20th January 2022

Application Nos.: 21/02337/DISC and 21/02339/REM

Proposal: Discharge of various conditions and reserved matters for first phase of 500 dwellings

Location: Proposed Himley Village North West Bicester
Middleton Stoney Road
Bicester
Oxfordshire

Building Heights | Not to scale

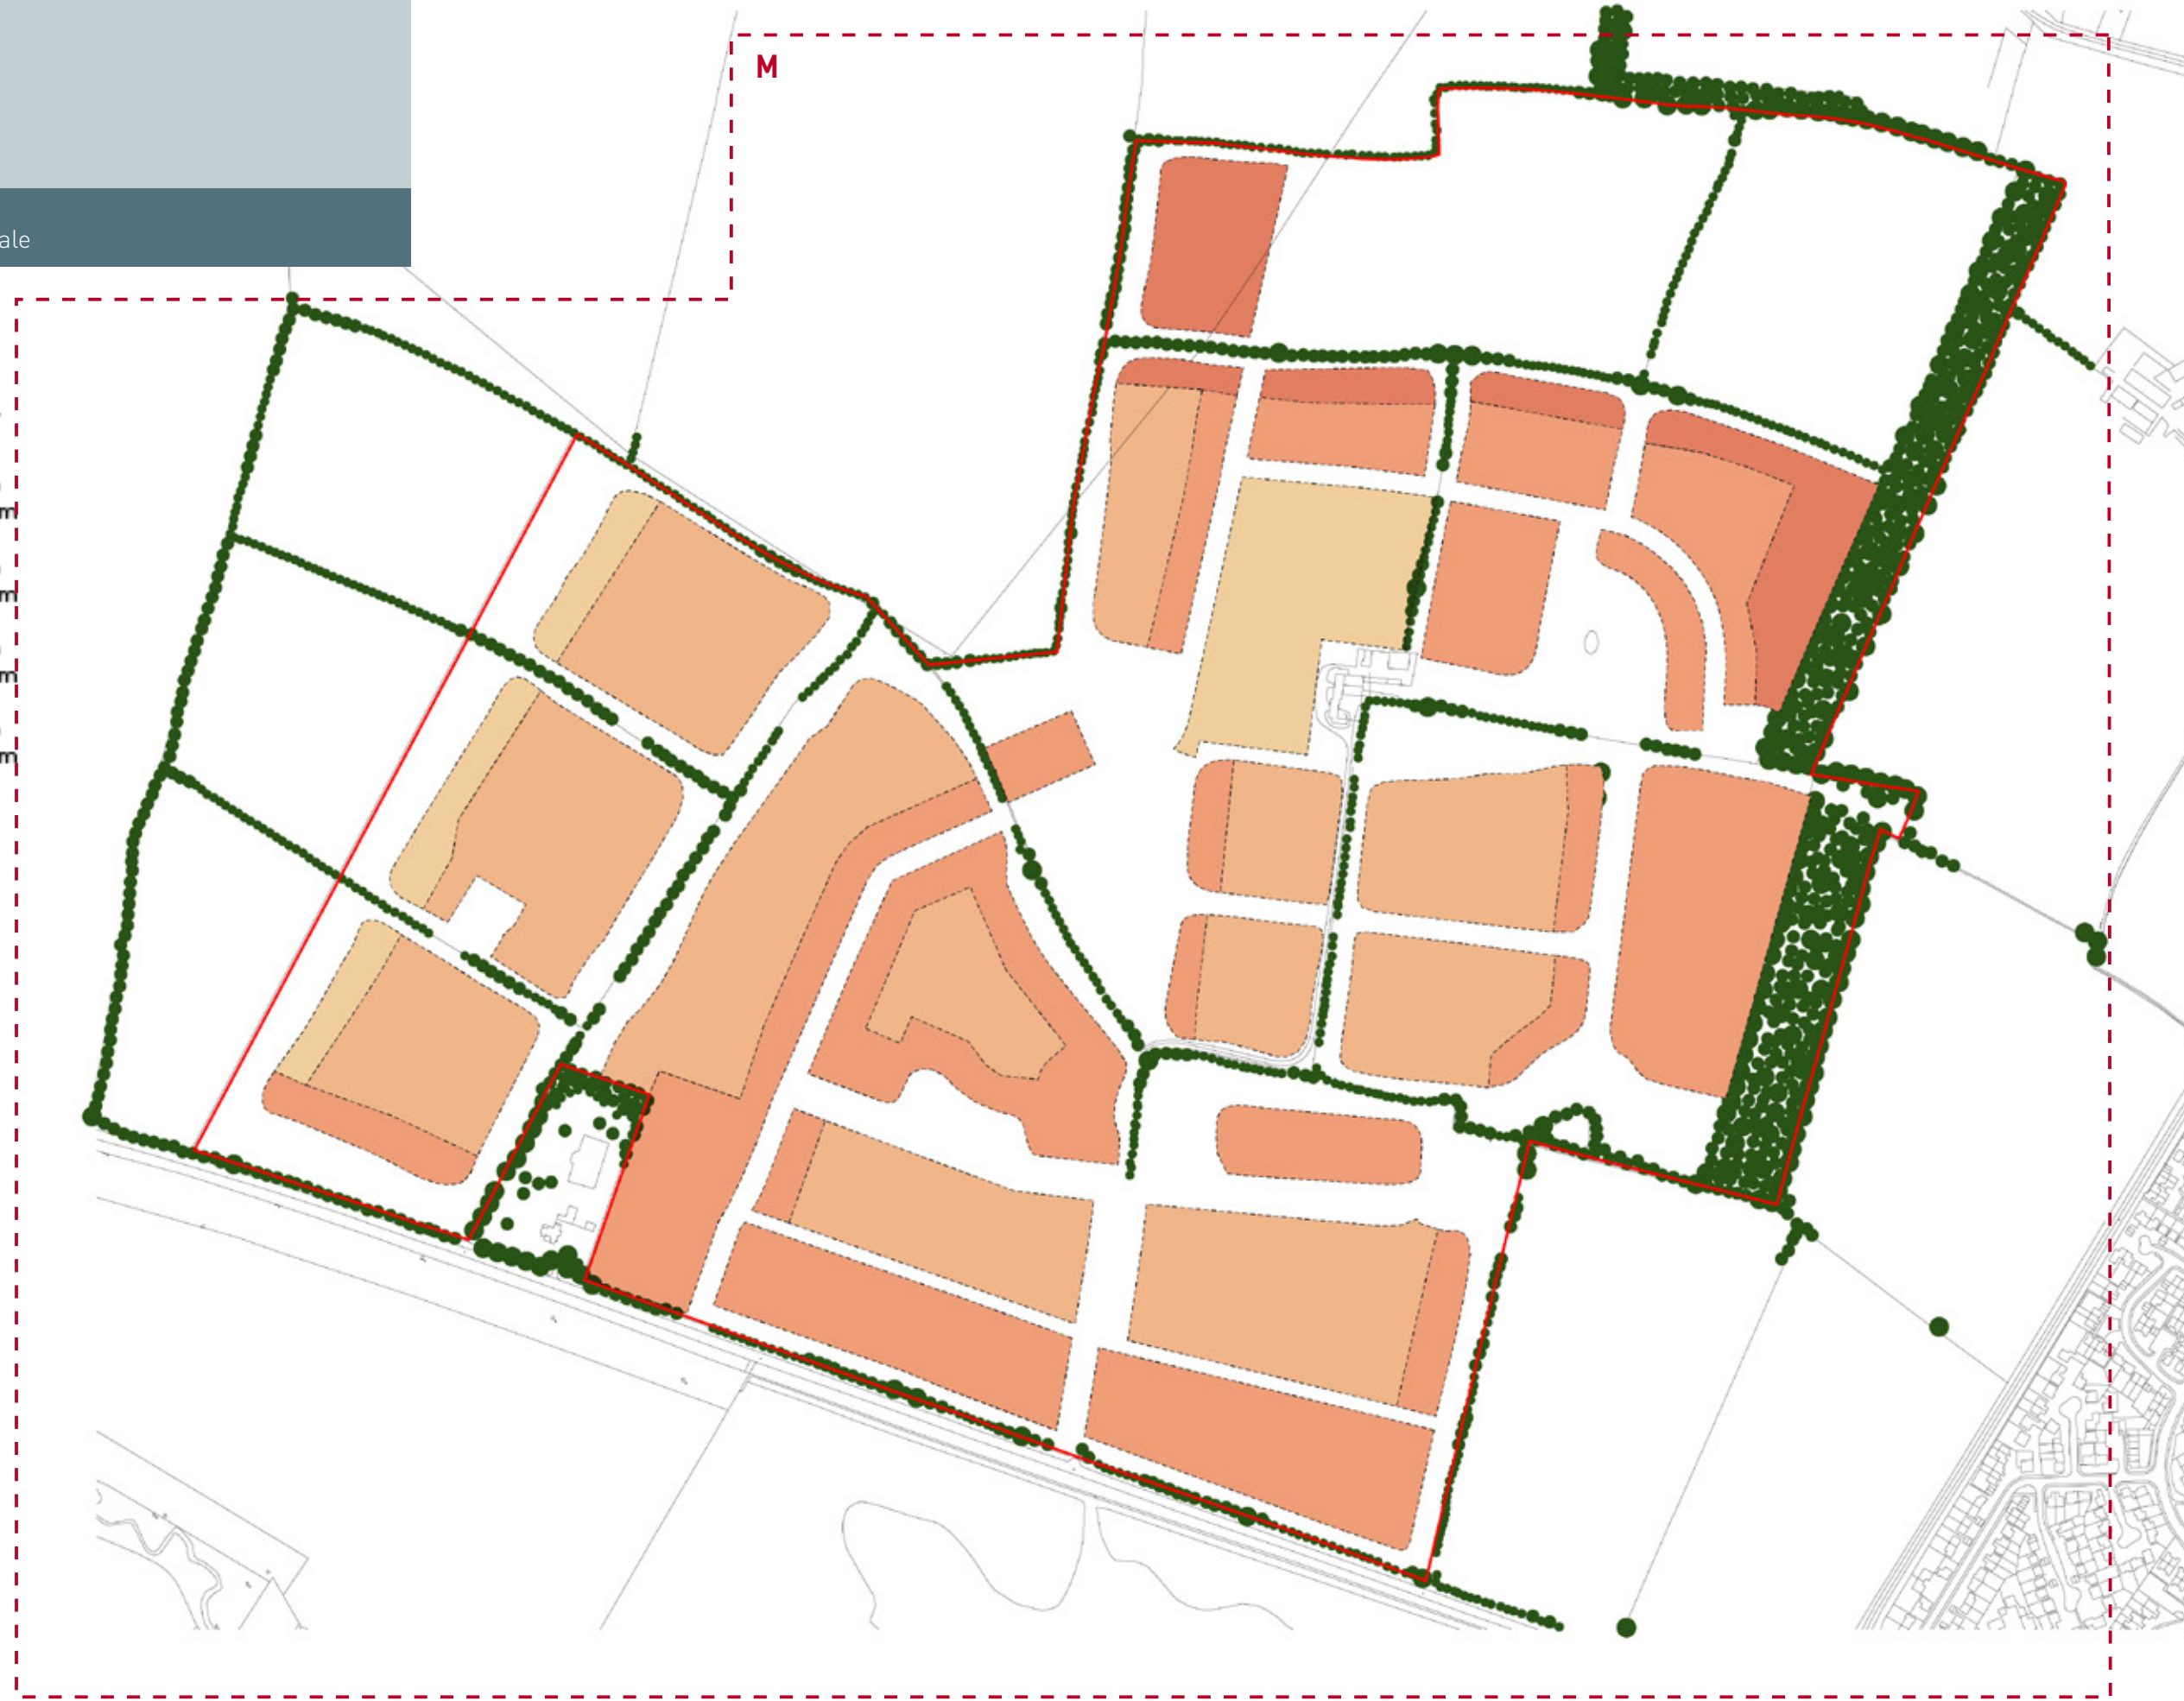
- I note that the Building Heights plan continues to be a direct replication of the approved parameter plan. No greater definition has been introduced so my previous comments have not been addressed. To clarify, I consider that the Design Code should introduce the next level of detail to the parameter plans. In some areas therefore, I would expect to see where building heights should be specified as being higher or lower in order to contribute to character – this is not necessarily across the whole site but in particular areas. A development of 4m versus a development of 17m at the Northern part of the site would give a very different character for example. I note the descriptive wording provided but no part of this section is mandatory, and it is ambiguous when the accompanying plan is not consistent.
